Form DCPR-4 - TCP COMMENT DISPOSITION FORM

Project: Bridge Boulevard - Phase I

Document Considered: Bridge PH I Reconstruction plans

Review Type: PS&E CABQ comments

Profile Report  
Profile: Profile - 100 Year Full Flow

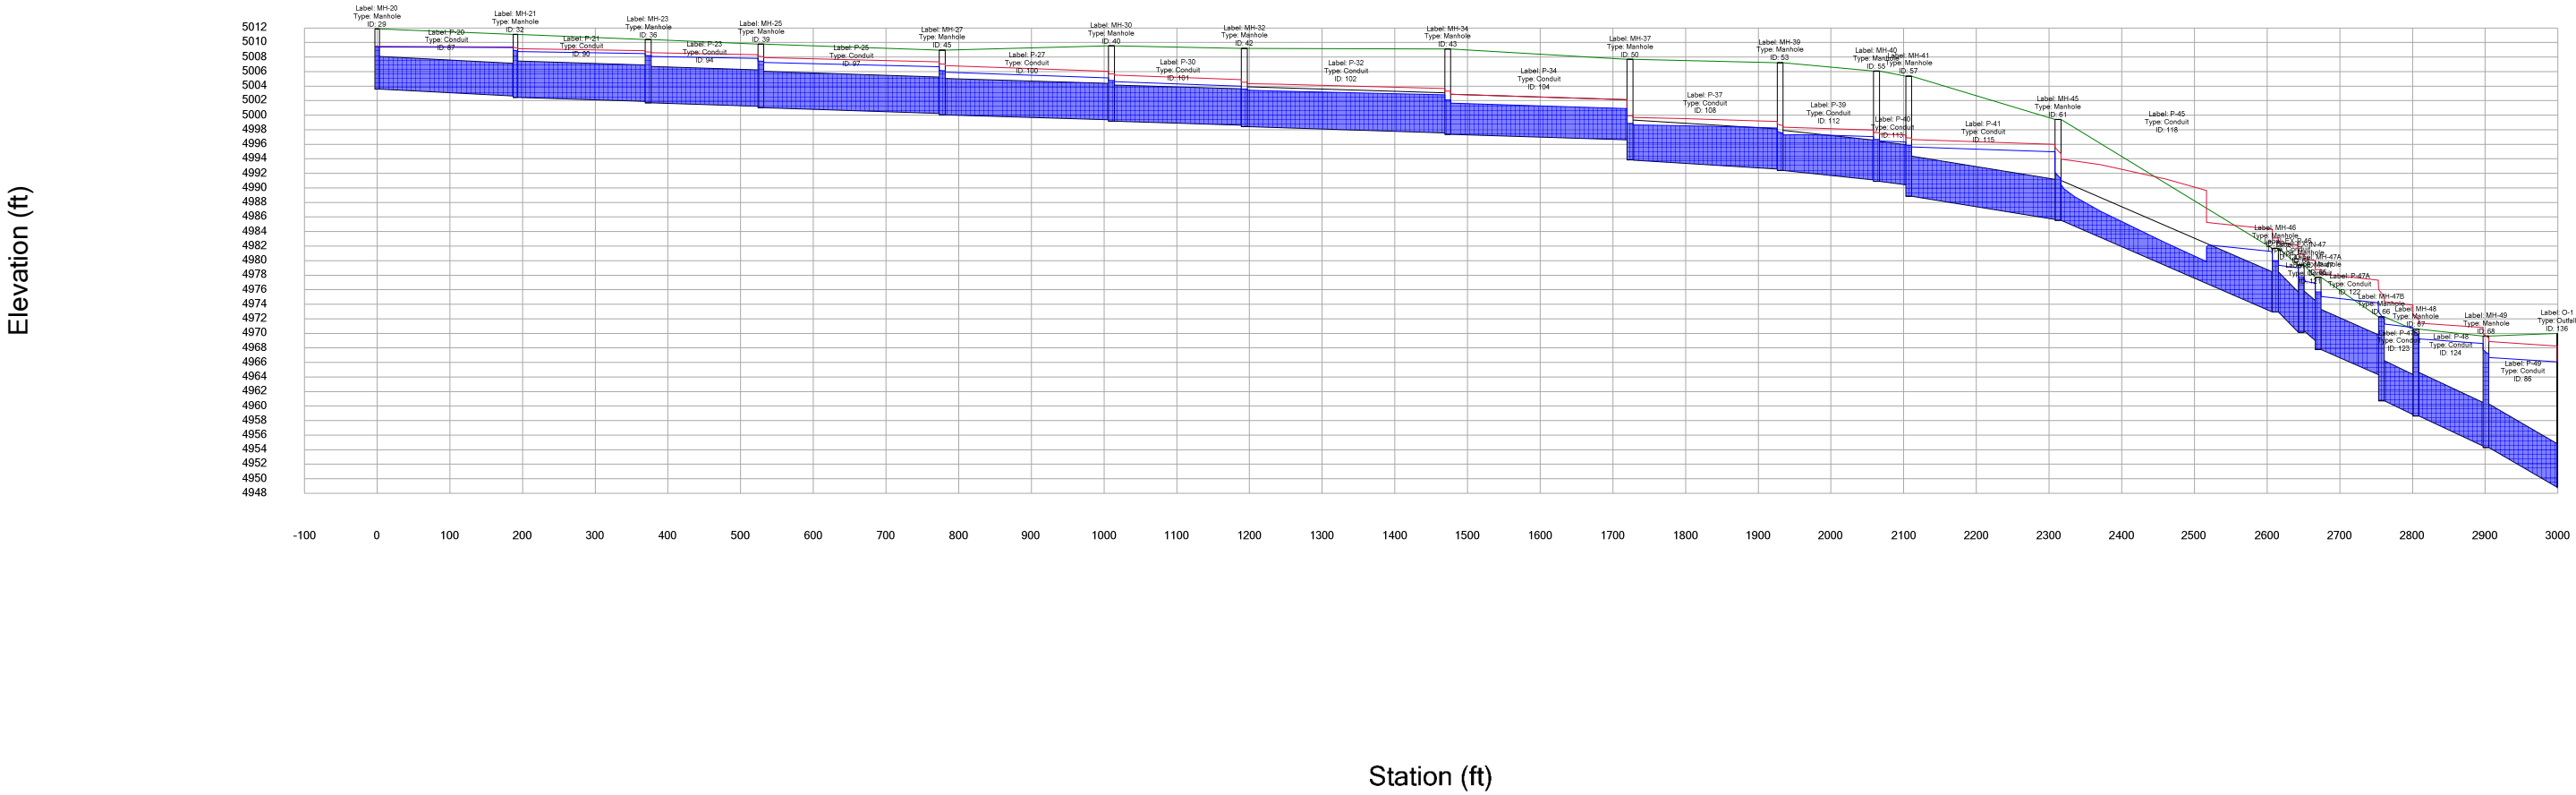
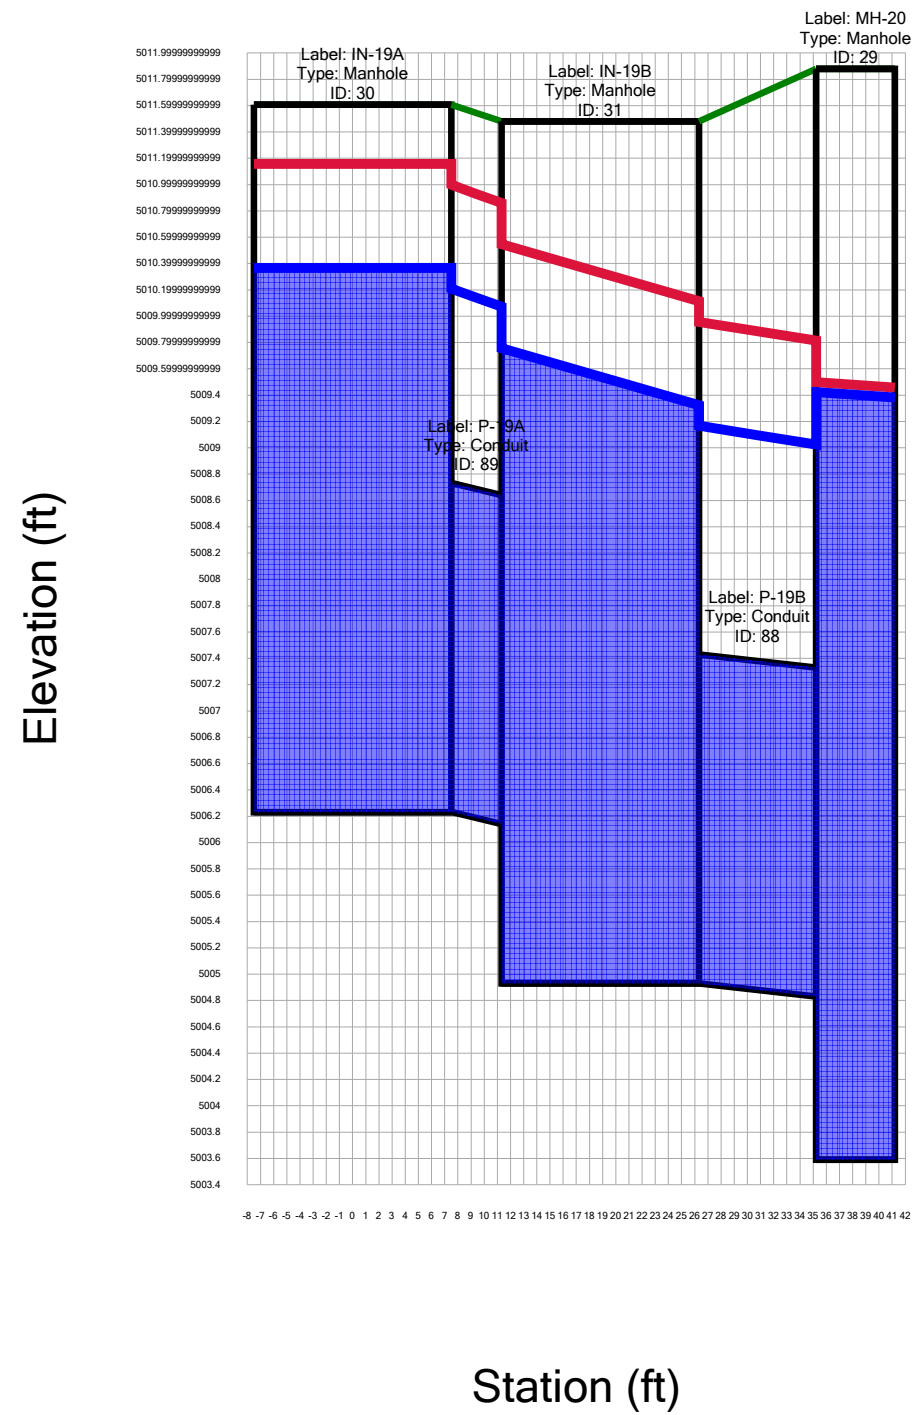
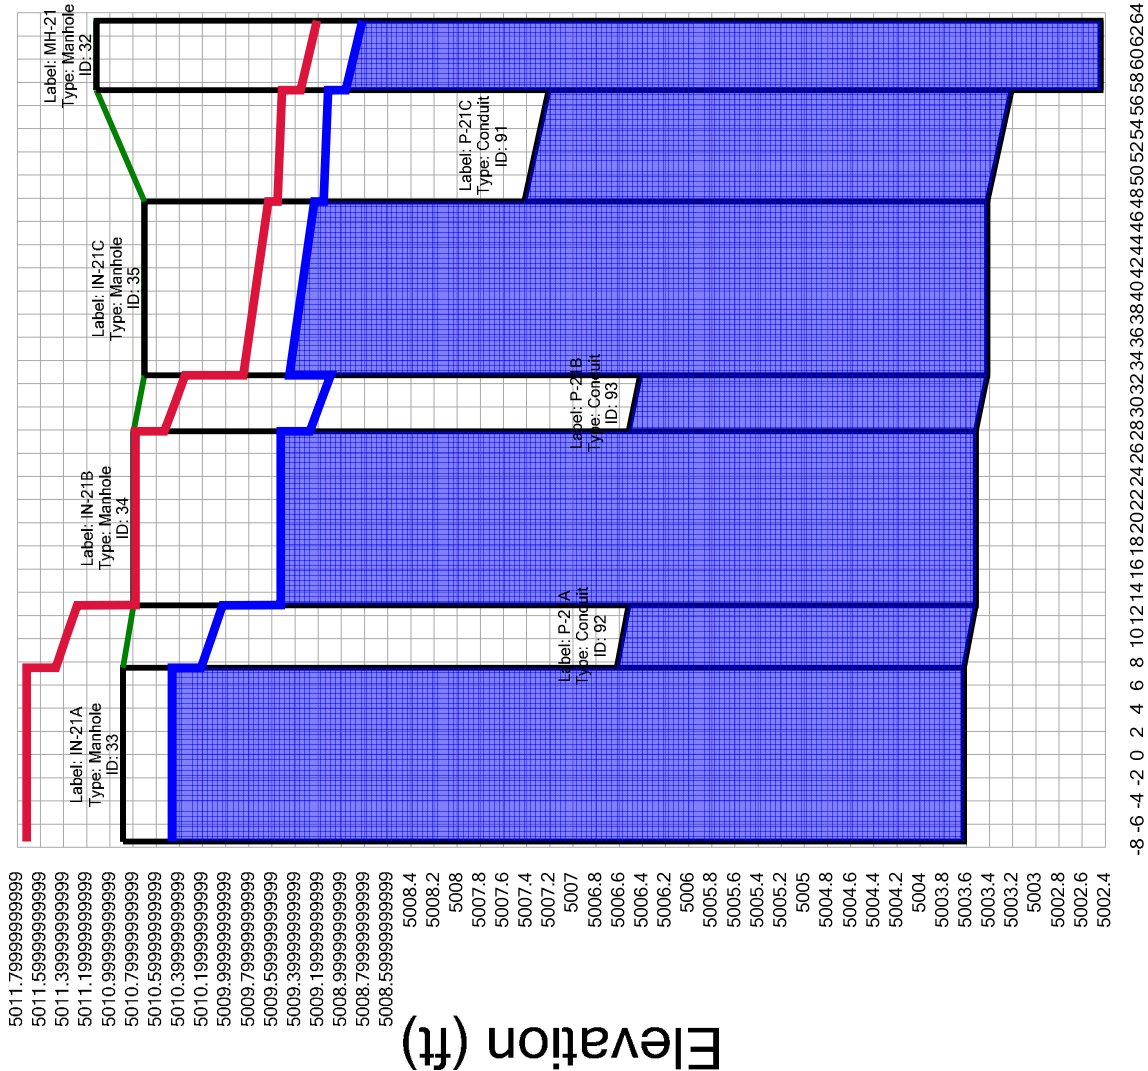
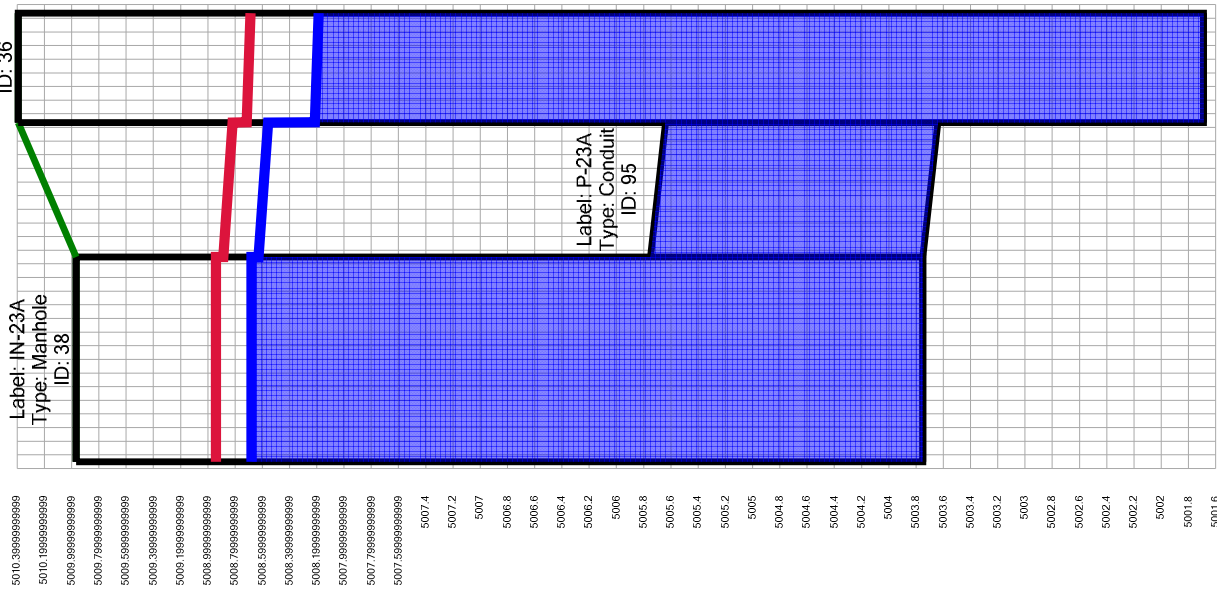
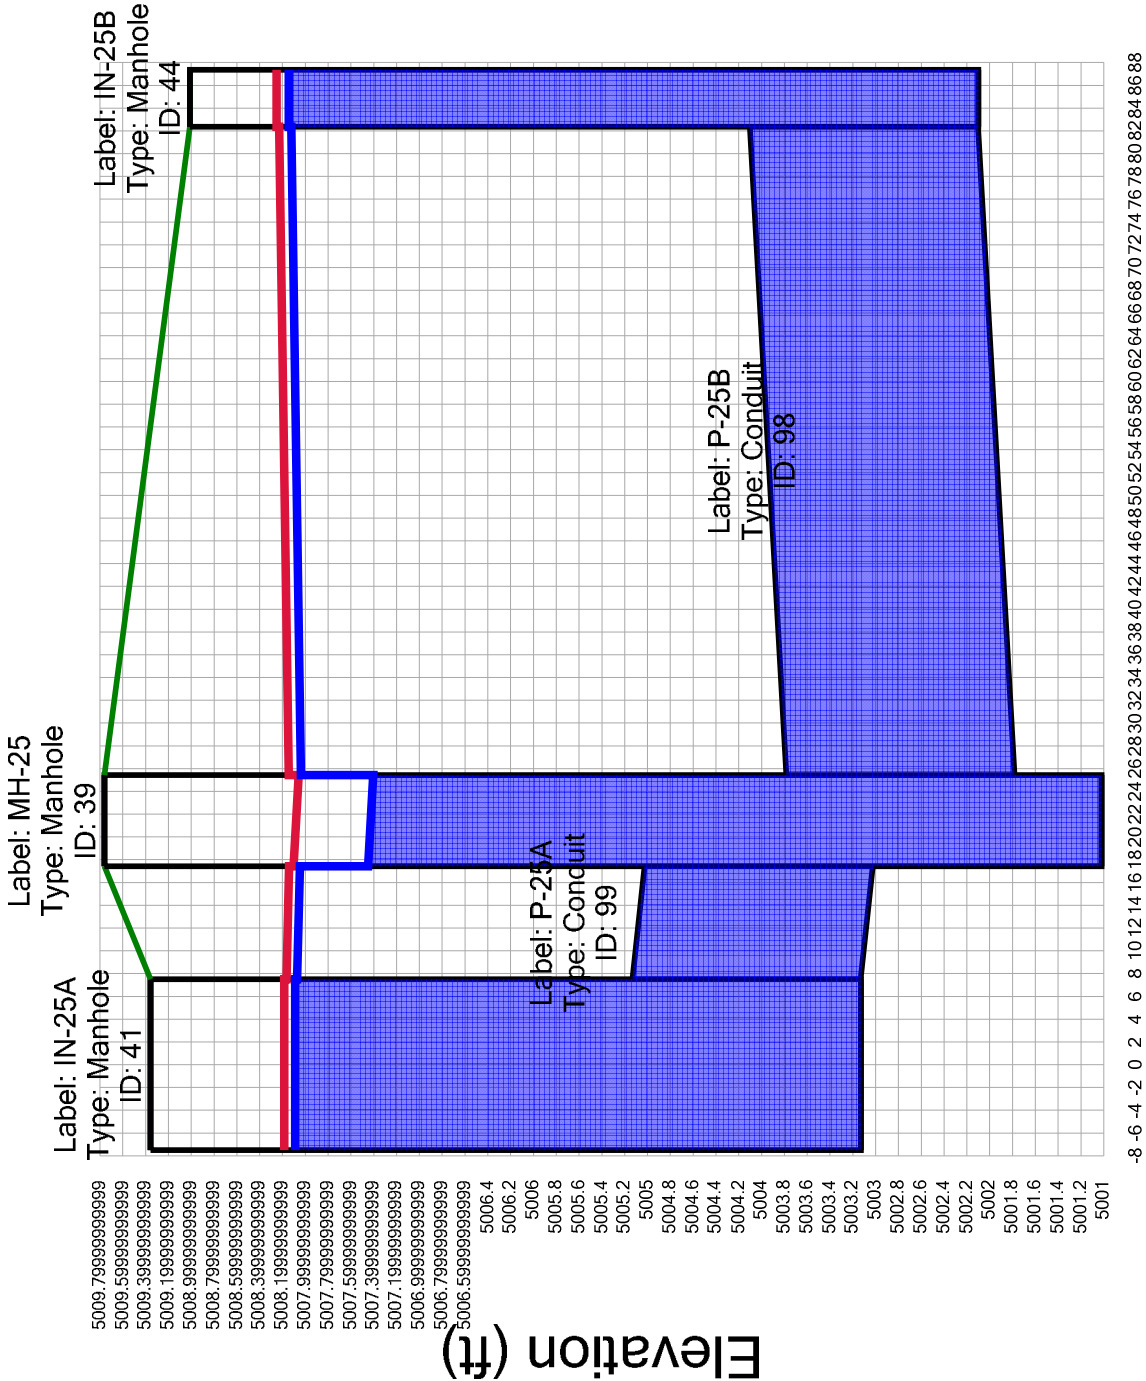
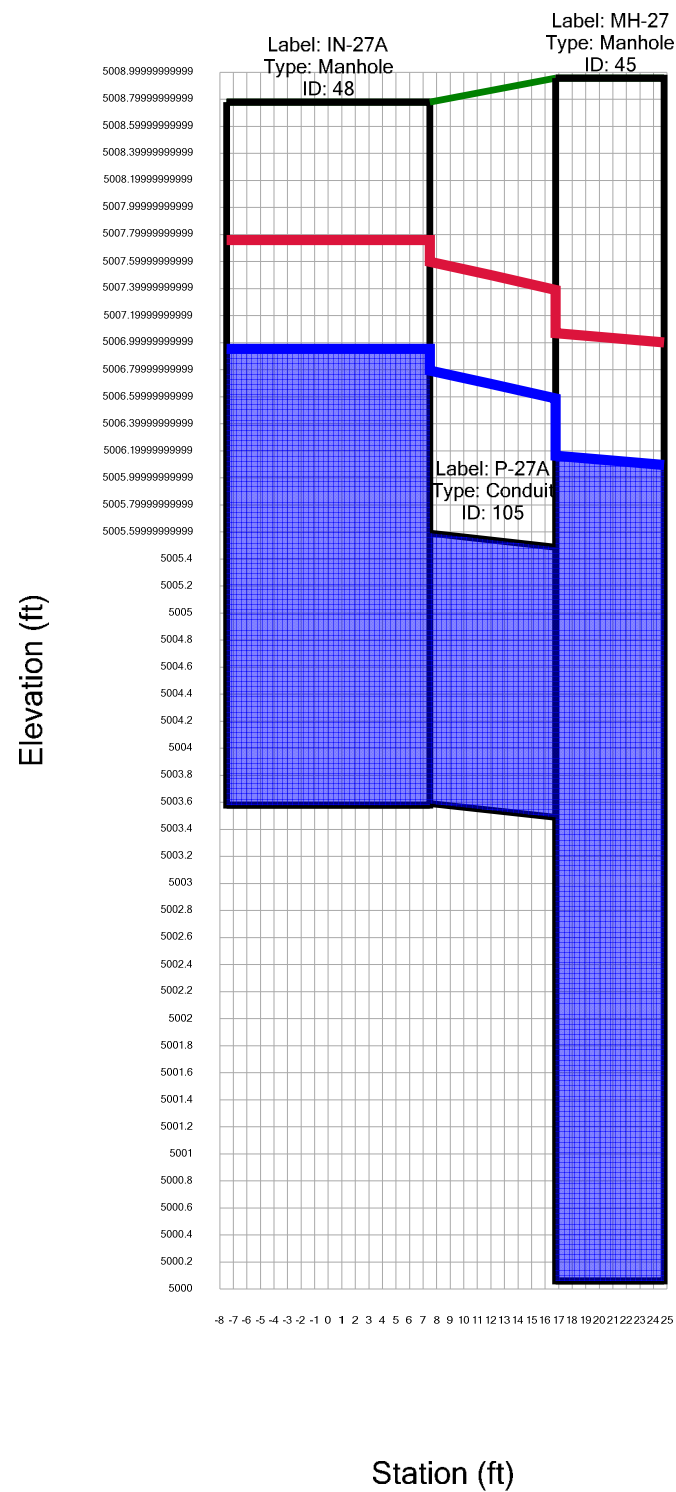
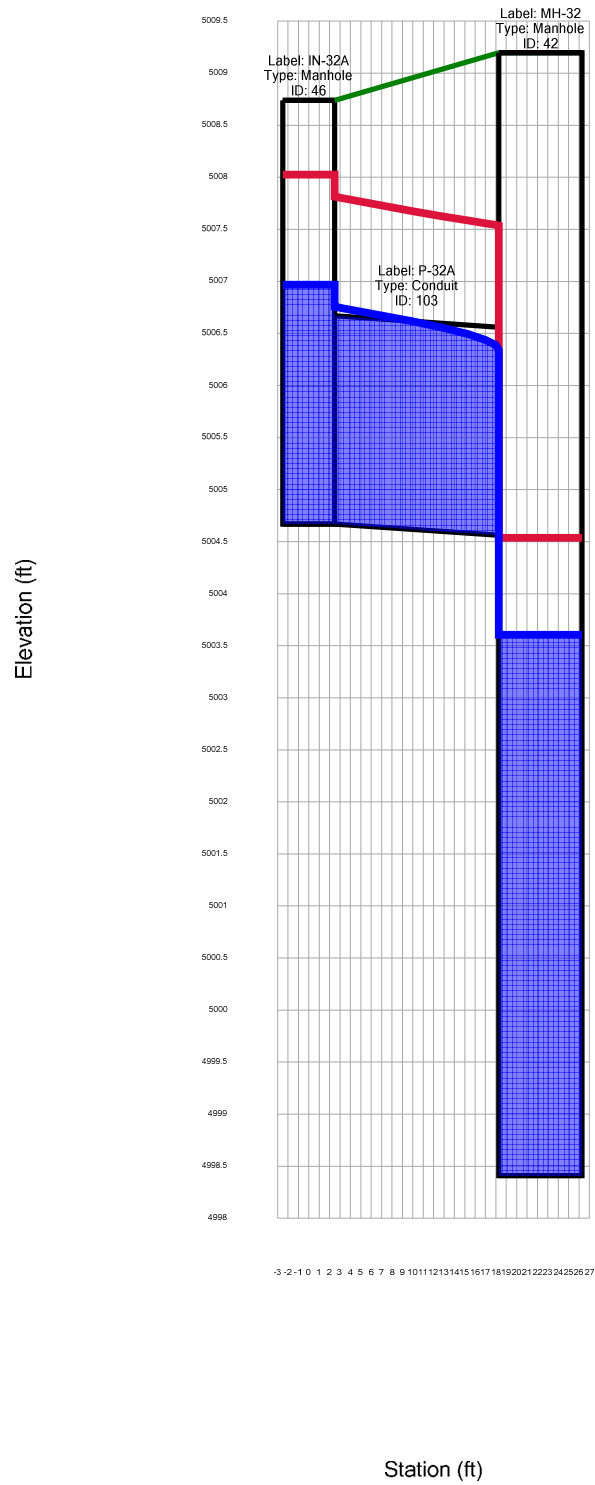
6	Analyse the impact of the new downstream pipes on the existing 36" RCP in Bridge that is to remain. HGL calculations required	HDR can provide a HGL comparison in existing and proposed conditions. However, proposed system is significantly larger than the existing system and HGL is below ground level as required in the criteria manual.
	146	7	The 2nd lane north of the median is dimensioned at 10'. Other lanes are 11'. and typical section shows 11'. Is this intentional?	Revise dimension to 11'
Roadway	N/A	8	A typical section from Station 201+96 to 205+27 is not provided. This is the confusing area with the 19' lane and the turn to Cortez.	See sht. 31 for Slip Lane typical Sections.
	153	9	Upper view: Your match line should refer to sheet 146	Revised matchline to refer to sht. 146 in lieu of 147.
